Sydney Olympic Park New High School

Architectural Response to SDRP Report

Authority: State Design Review Panel

1 PROPOSED ELEVATION 1
SCALE 1:200

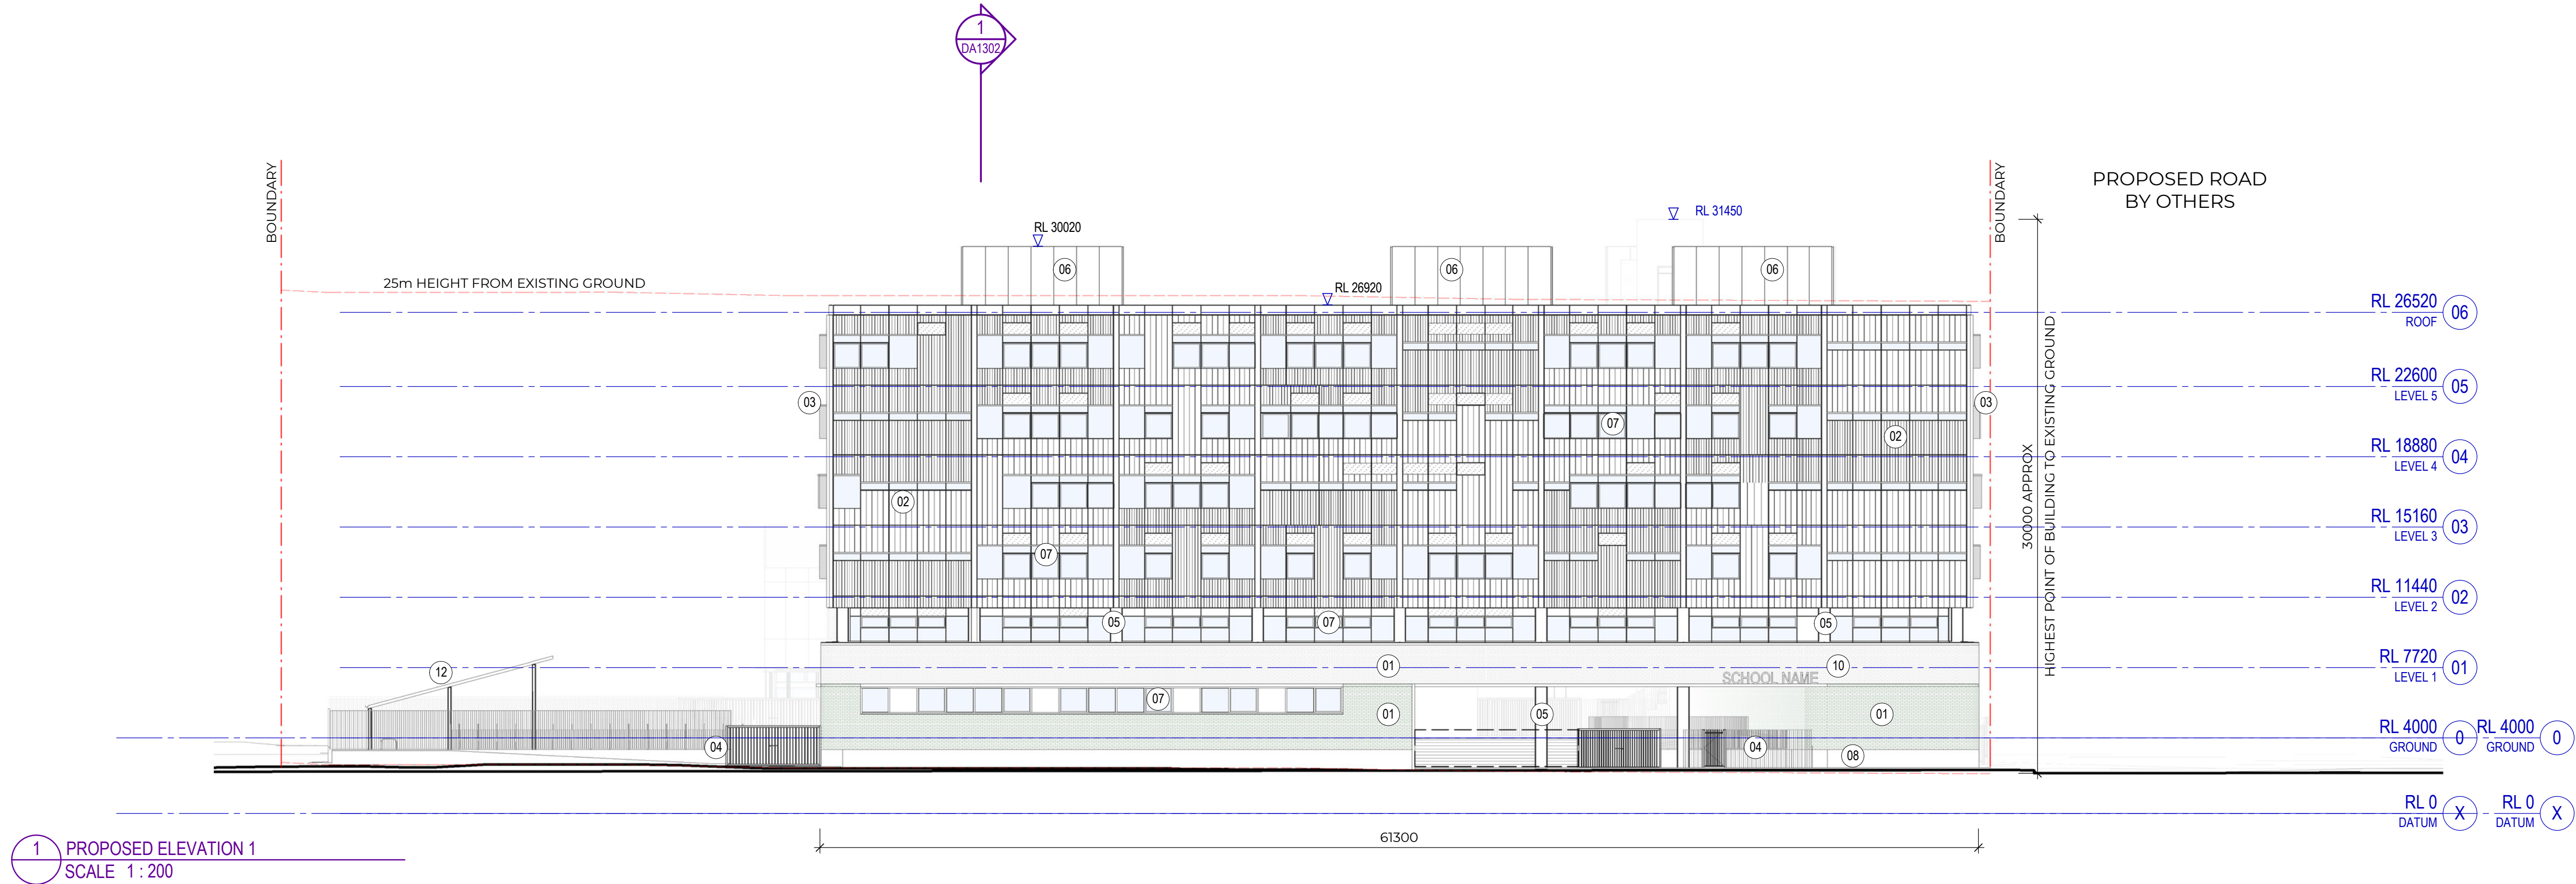
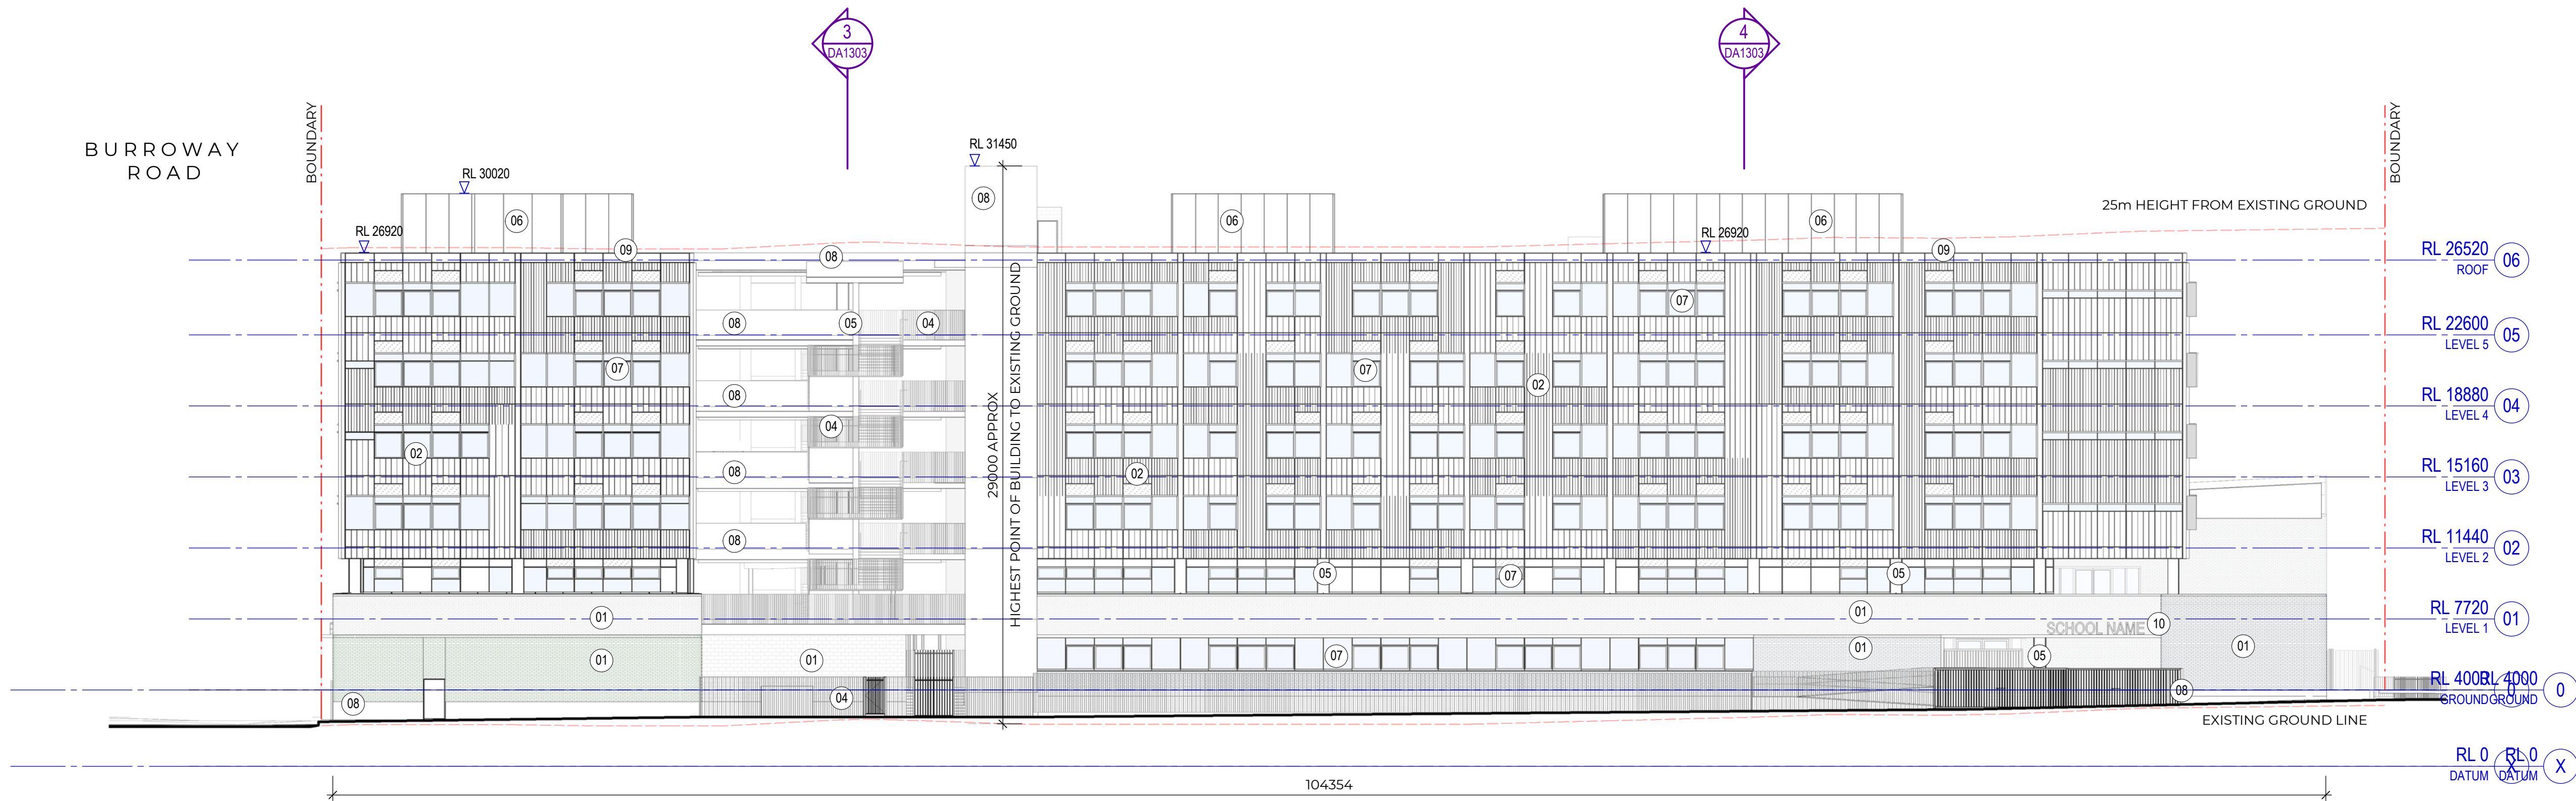
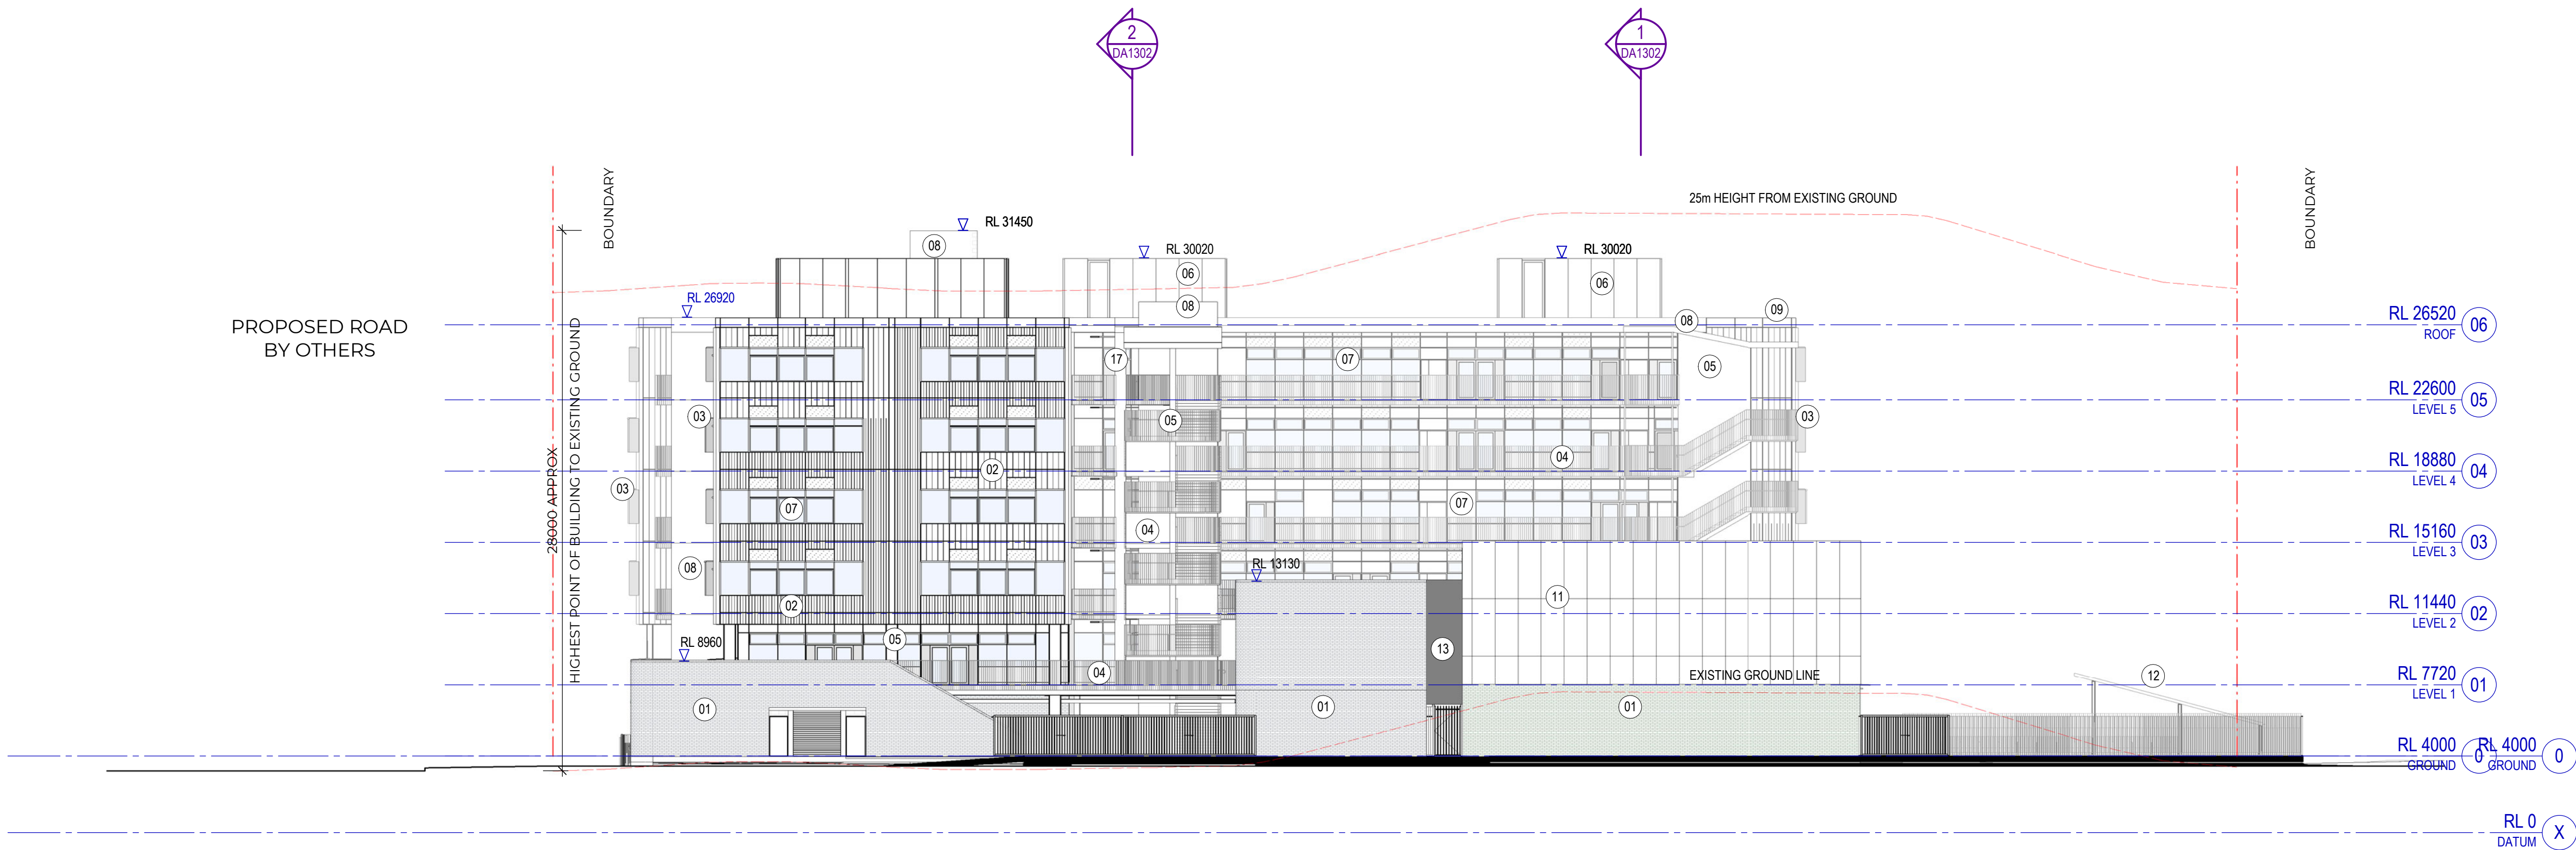
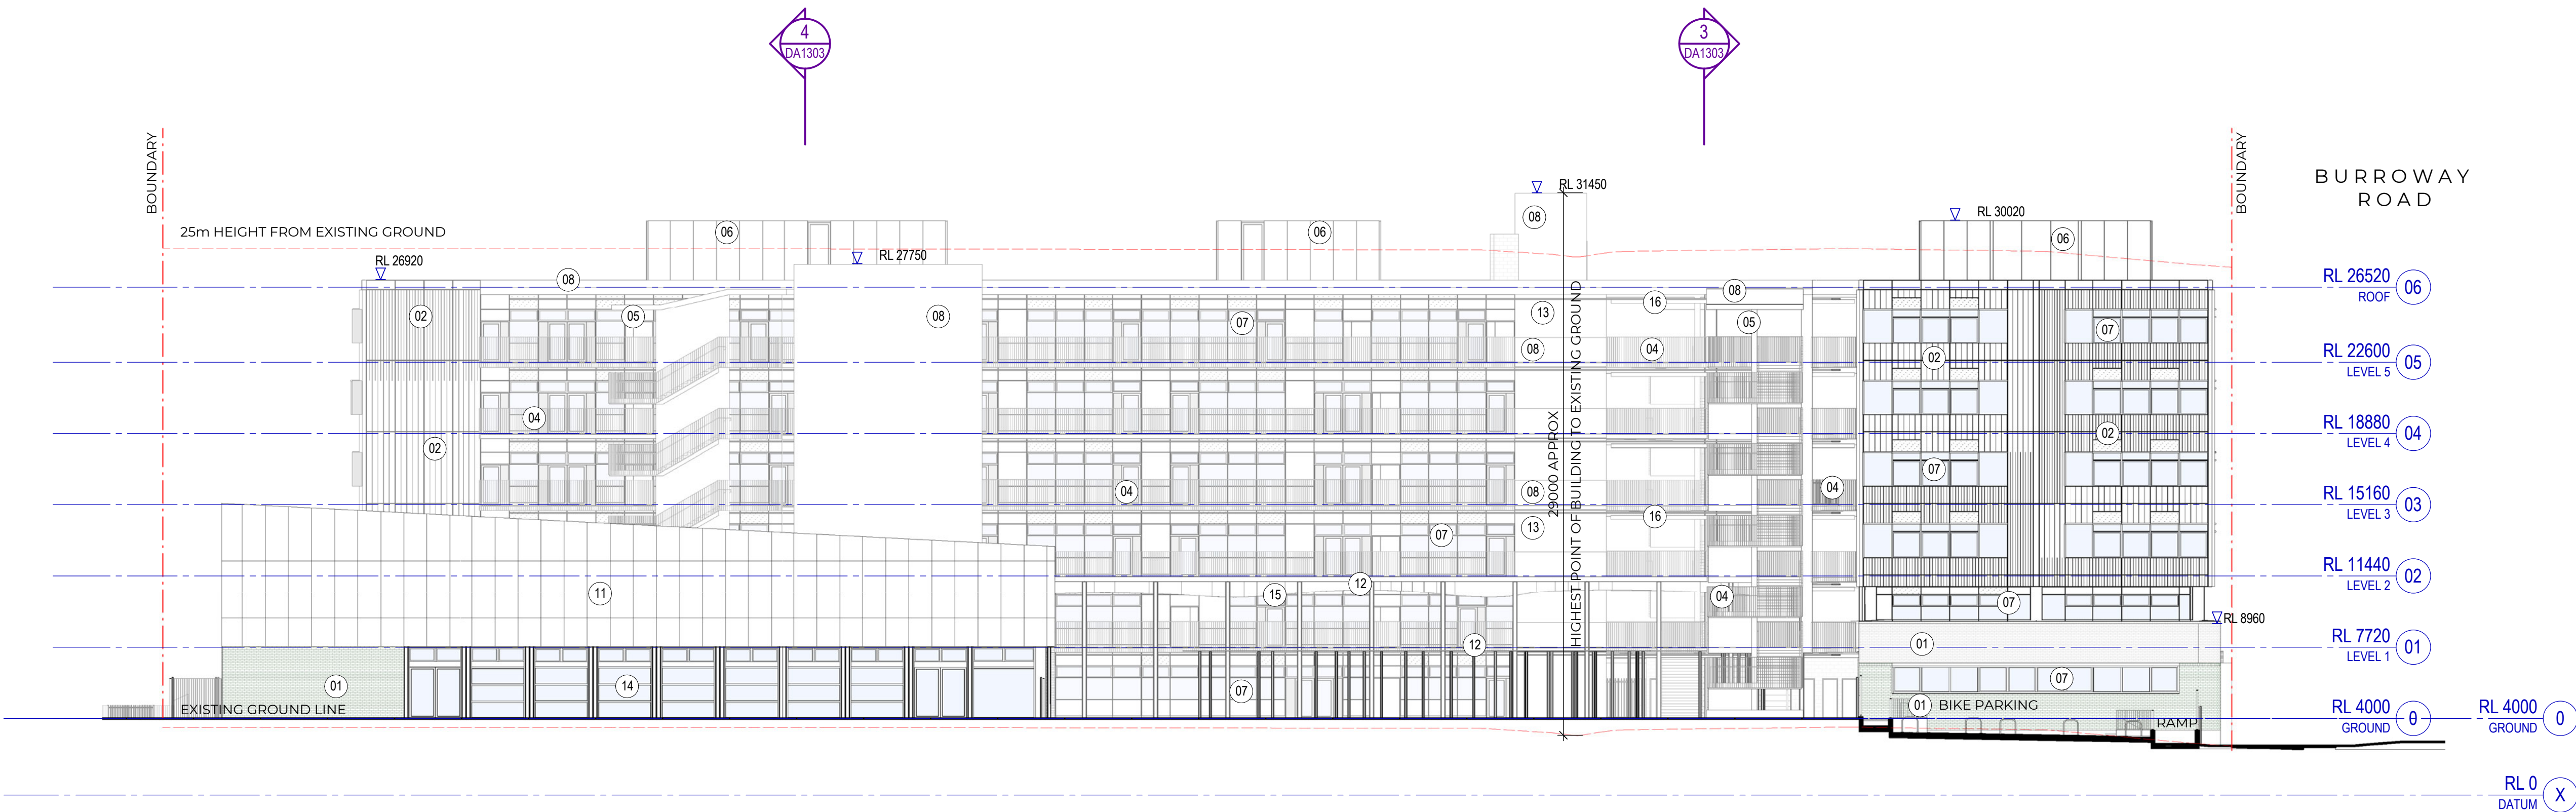
Comment: Building as boundary – The fences along the boundary of Eastern Road appear unwelcoming and are an inappropriate urban response. Undertake further design development to enable the building to define the urban edge. Provide a diagram clearly indicating the extent, height and character of all proposed fencing lines.

The design has evolved since the SSD submission. The building is setback from the boundary ensuring a large distance from the eastern road.

As the design evolved, there is no longer a requirement for a dedicated support learning play area, but instead a need for a better integration to the main building. The removal of the retaining wall which was supporting this outdoor play area – an unarticulated, opaque barrier – allows a generous planting while also defining the school's interface with the eastern road. The result is an edge condition that is better scaled and more sympathetic to pedestrians. The landscaped area acts as a generous buffer between the support learning unit and the public domain. The palisade fence remains as a requirement for school security – it protects the windows of the support learning unit, which are too close to the ground to be properly secured.

Another change along the eastern road boundary is the removal of the projecting canopy over the school entry point at the north-east corner of the site. The canopy is now a simple undercroft, aligned with the building at the canteen and support learning unit. As a result, the entry point is now a clearer and more legible element within the overall massing.
